Road Safety Audit – A29 Shripney Road

Stage: 1

Location: A29 Shripney Road, Shripney, West Sussex

Site: Proposed right turn lane and new site access

PROJECT: SHRIPNEY ROAD, SHRIPNEY		
CLIENT: HANBURY PROPERTIES		
PROJECT REFERENCE: 1845	DRAWING NUMBER: 03	SCALE: VARIES

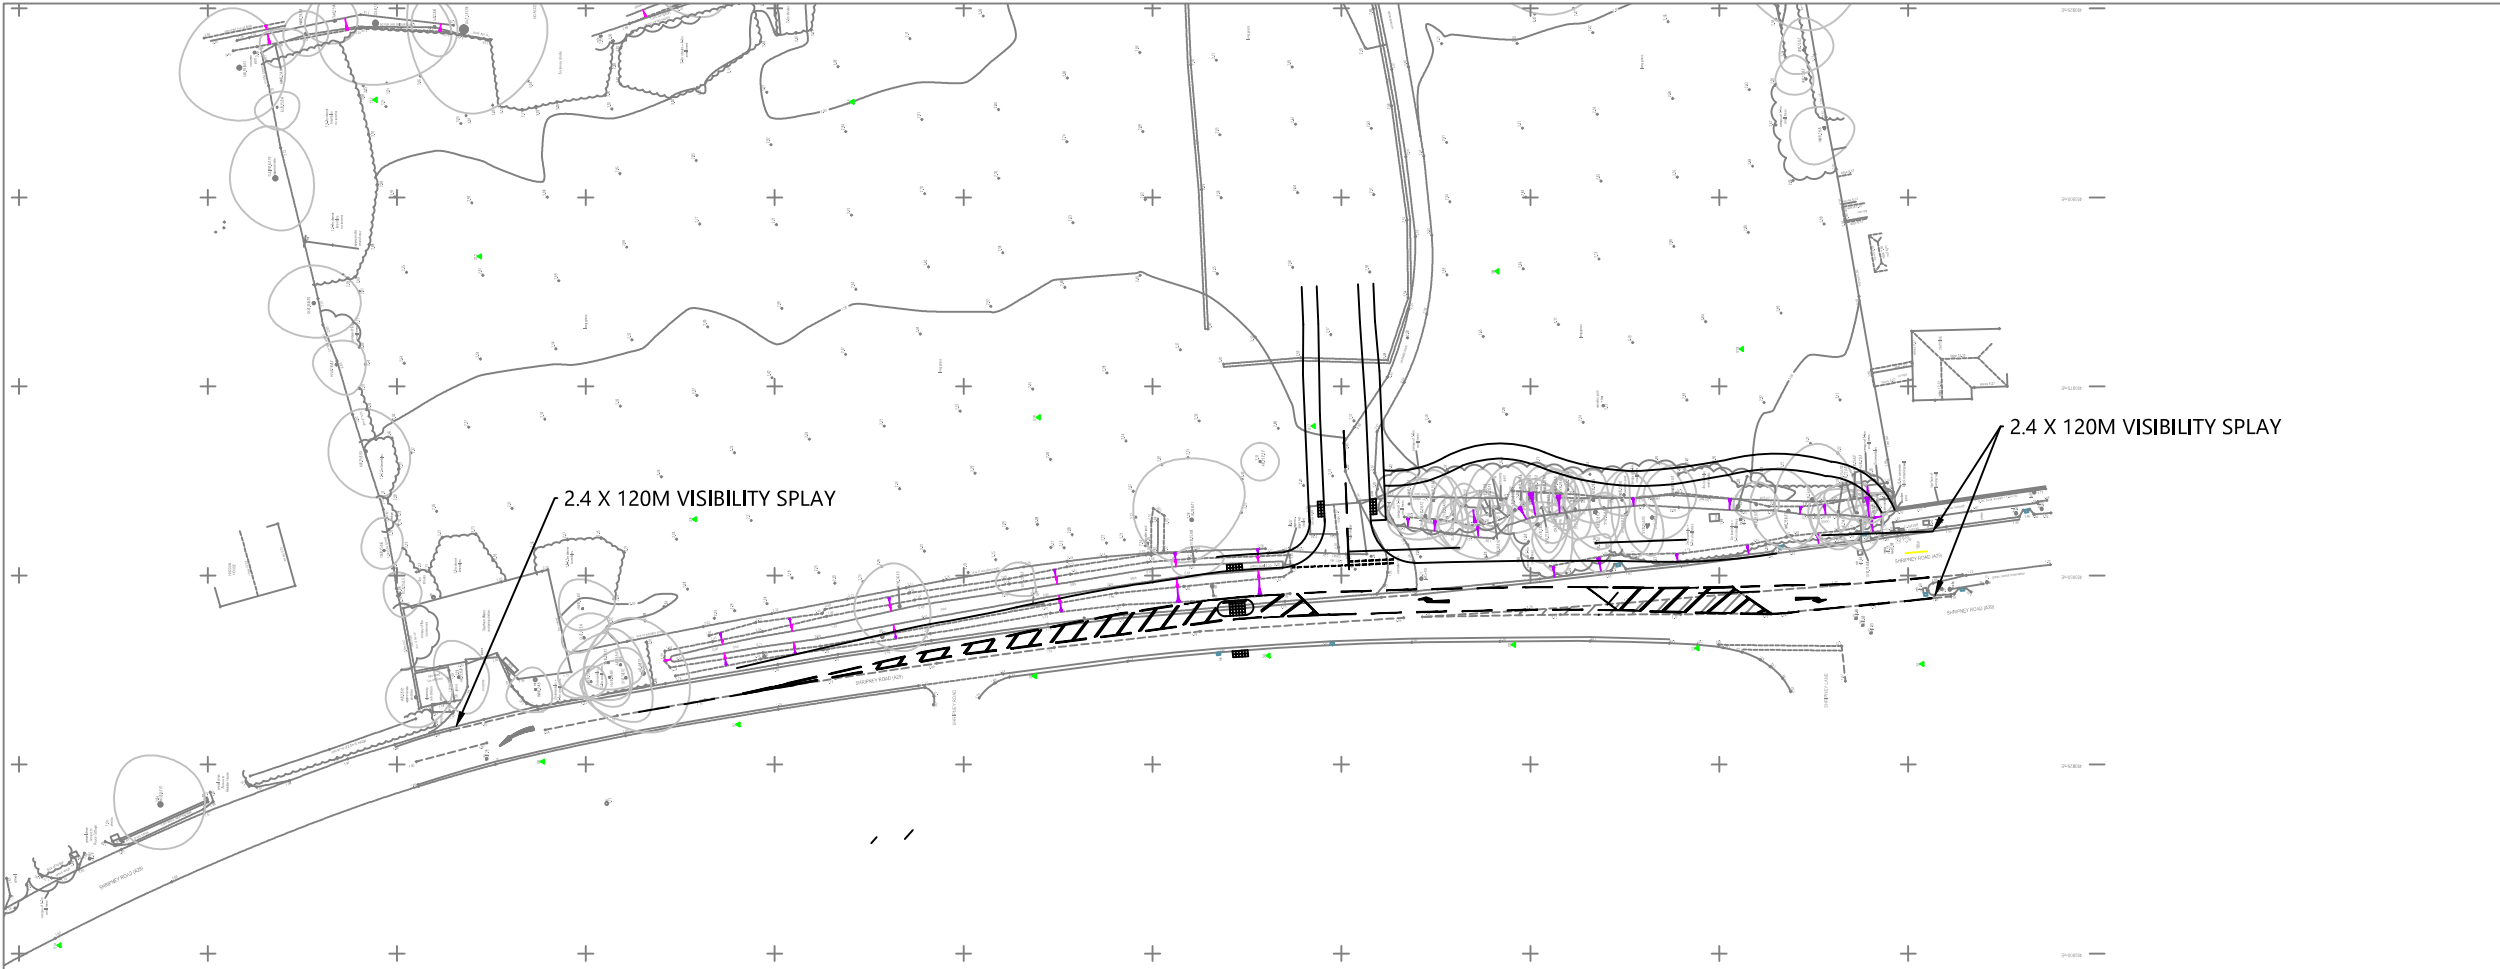
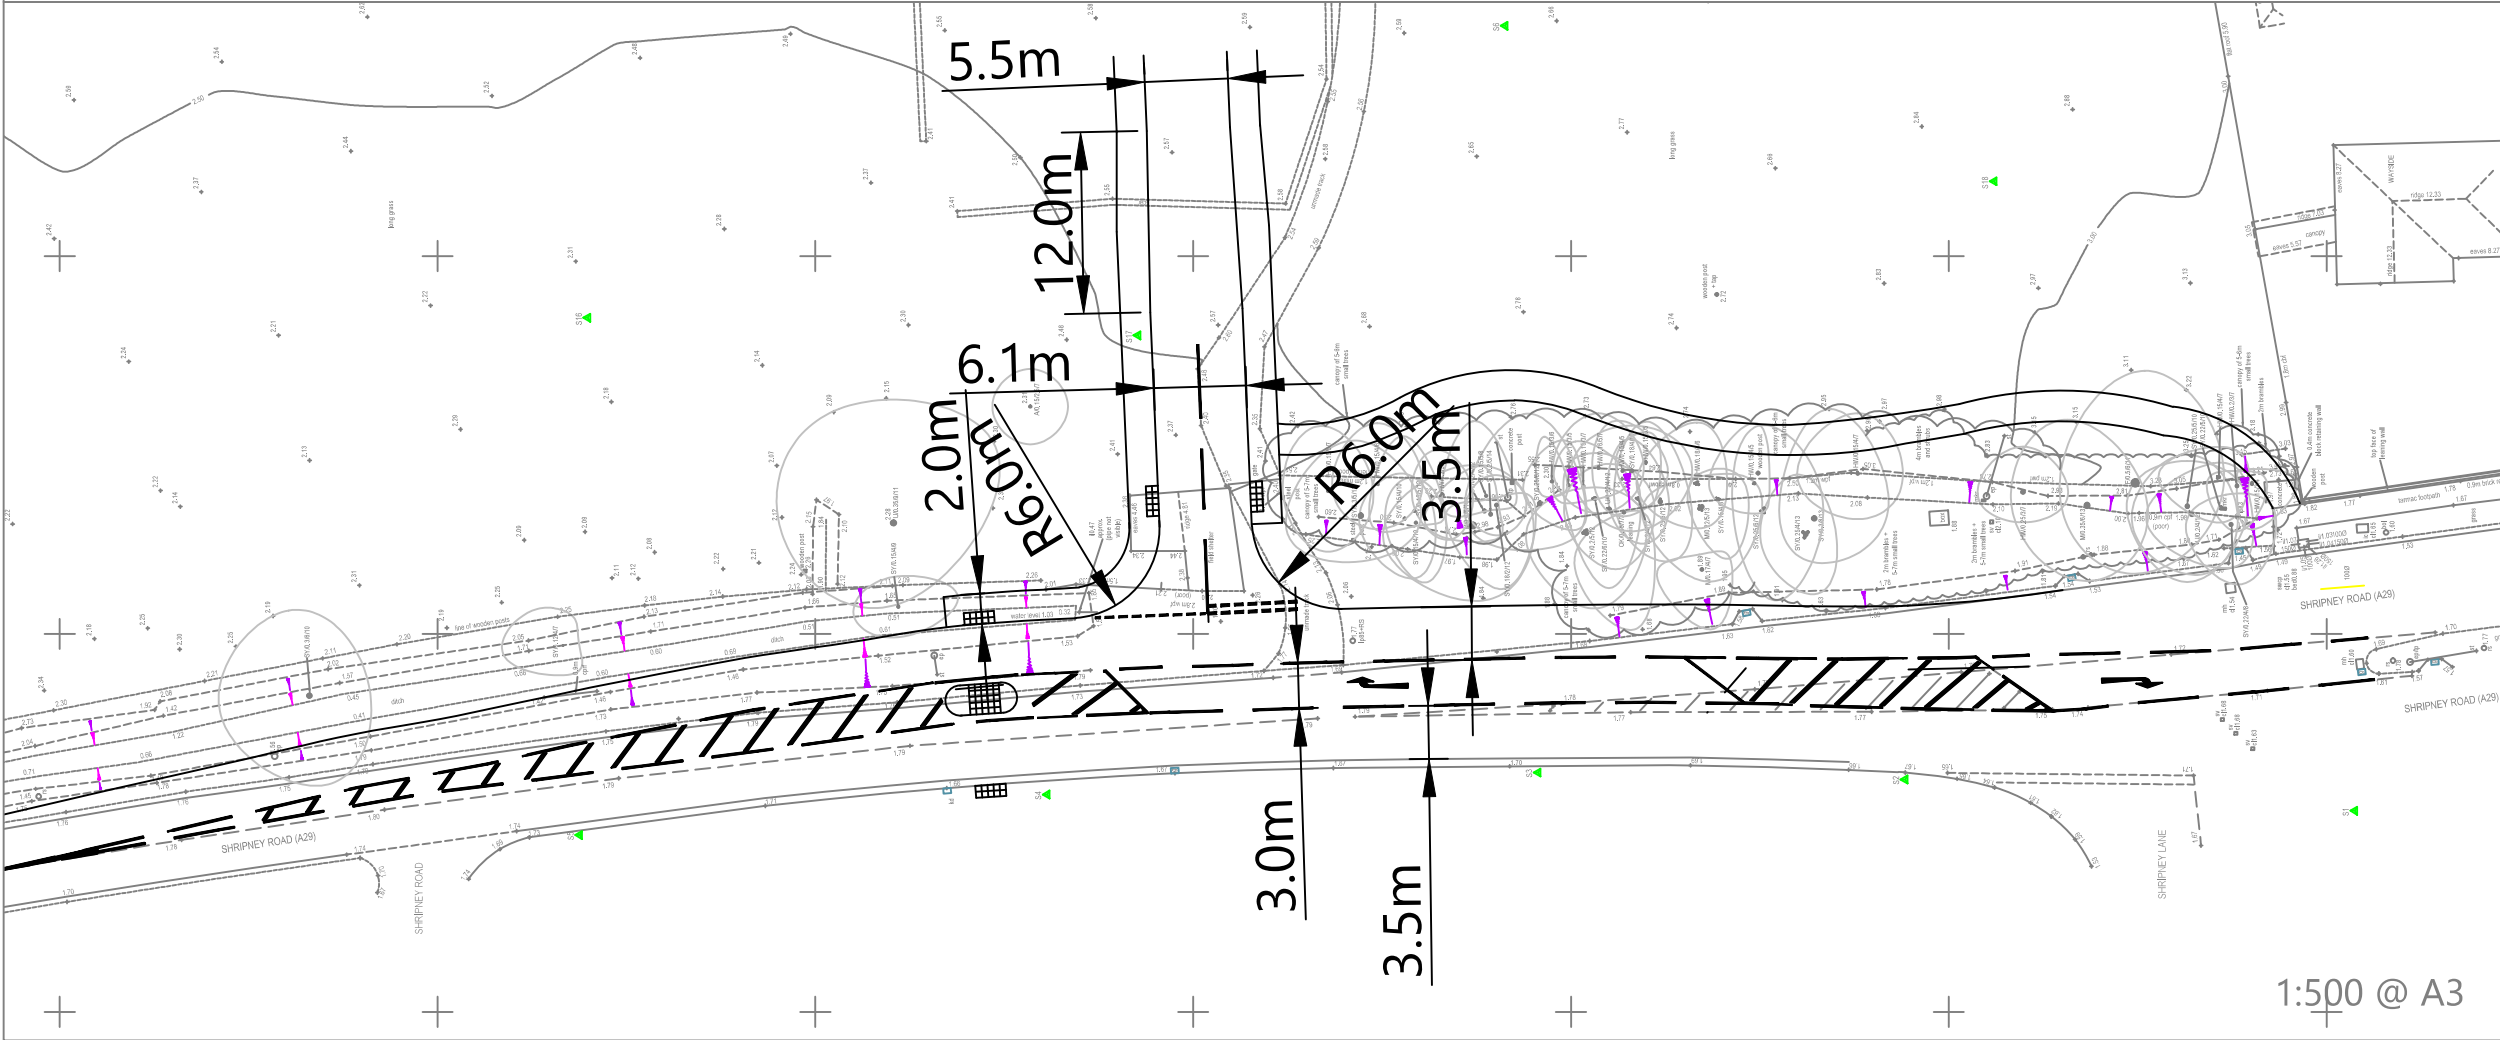
Location – Proposed access into the development

Summary – Risk of junction collisions due to a lack of visibility.

Vehicles exiting the proposed junction onto the A29 have obscured visibility in both directions due to the presence of foliage. This will increase the risk of junction collisions, an issue exacerbated by high speeds of approaching vehicles (see photos 2.1a and 2.1b).

Recommendation – Remove the foliage/hedgerow and ensure sight lines are unobstructed and maintained.

2.2 Problem

Location – Proposed junction

Summary – Risk of conflict at the junction due to inadequate space for larger vehicles to manoeuvre.

The vehicle tracking shows that larger vehicles encroach onto the opposite carriageway when turning left out of the junction or right into the access. This will lead to conflict with vehicles waiting at the junction (see drawing 1845 TR02).

Recommendation – Reconfigure the junction to allow larger vehicles to manoeuvre within the junction without encroaching into oncoming/waiting traffic.

2.3 Problem

Location – Proposed realigned southbound carriageway

Summary – Risk of increased severity following loss of control collisions.

A ditch is currently present on the east side of the existing carriageway. The proposed realignment will move road users closer to this ditch which will increase the risk of vehicles ending up in the ditch following loss of control collisions (see Photo 2.1b).

Recommendation – Provide a road restraint system to protect road users from falling into the ditch.

2.4 Problem

Location – Proposed pedestrian crossing point- west side

Summary – Risk of pedestrian/vehicle conflict due to a lack of visibility.

When crossing west to east at the proposed informal crossing point, foliage is currently obscuring the visibility of approaching vehicles from the south, increasing the likelihood of pedestrian/vehicle conflict (see Photo 2.4).

Recommendation – Remove the existing foliage and establish methods to permanently maintain required sight lines.

2.5 Problem

Location – Proposed pedestrian crossing point- west side

Summary – Risk of vehicle/pedestrian conflict due to low upstand of the existing kerb.

The proposed pedestrian crossing point is located in a position where the upstand of the existing footway is insufficient. This increases the risk of vehicles mounting the footway in a location where pedestrians are encouraged to cross the road (see Photo 2.5).

Recommendation – Reconstruct the existing footway on the west side to provide a sufficient upstand which will give the carriageway greater delineation and provide protection for pedestrians.

2.6 Problem

Location – Proposed access to the site

Summary – Risk of shunts and head on collisions due to parked vehicles.

Vehicles parking on the proposed access road near the junction will cause vehicles turning into the site to perform a slower than expected manoeuvre. Due to the fast approaches to this site, this increases the risk of nose to tail collisions while vehicles perform this manoeuvre, or may lead to vehicles entering the site at speed and colliding head on with a parked vehicle.

Recommendation – Implement ‘No Waiting At Any Time’ restrictions around the junction.

2.7 Problem

Location – Proposed realigned southbound carriageway

Summary – Risk of pedestrian falls due to unprotected ditch

As mention in Problem 2.3, the road realignment will lead road users closer to the ditch that currently runs parallel to the southbound carriageway. If left unprotected, pedestrians using the proposed new footway on the east of the A29 are at risk of falling into the ditch (see Photo 2.1b).

Recommendation – Provide appropriate protection for pedestrians to prevent them from falling in the ditch.

Designer's response – Foliage within the visibility splays to be cut back as part of access highway works and maintained by appropriate parties

Designer's response – Access radii to be widened to each side of access

Designer's response – The ditch will be culverted as part of the access highway works, in line with an appropriate drainage strategy. As part of the Works Agreement with the LHA the need for restraint systems will be discussed.

Designer's response – Any vegetation obscuring visibility in this location is as a direct result of encroachment onto the public highway. Such vegetation is regularly cut back and maintained as part of the public highway. It is within the powers of the LHA to serve notice on properties where vegetation is overhanging the public highway. The developer can ensure that any vegetation overhanging the public highway on the approaches to the proposed pedestrian crossing is cut back as part of the access highway works.

Designer's response – It is considered that works to the kerb line on the western side of the carriageway, along the length of the site frontage, can be encompassed within the detailed design.

Designer’s response – This can be considered with WSCC at the detailed design stage. It should be noted that the development parking provision fully meets local standards including parking for visitors.

Designer’s response – A double yellow line TRO can be considered at detailed design stage.
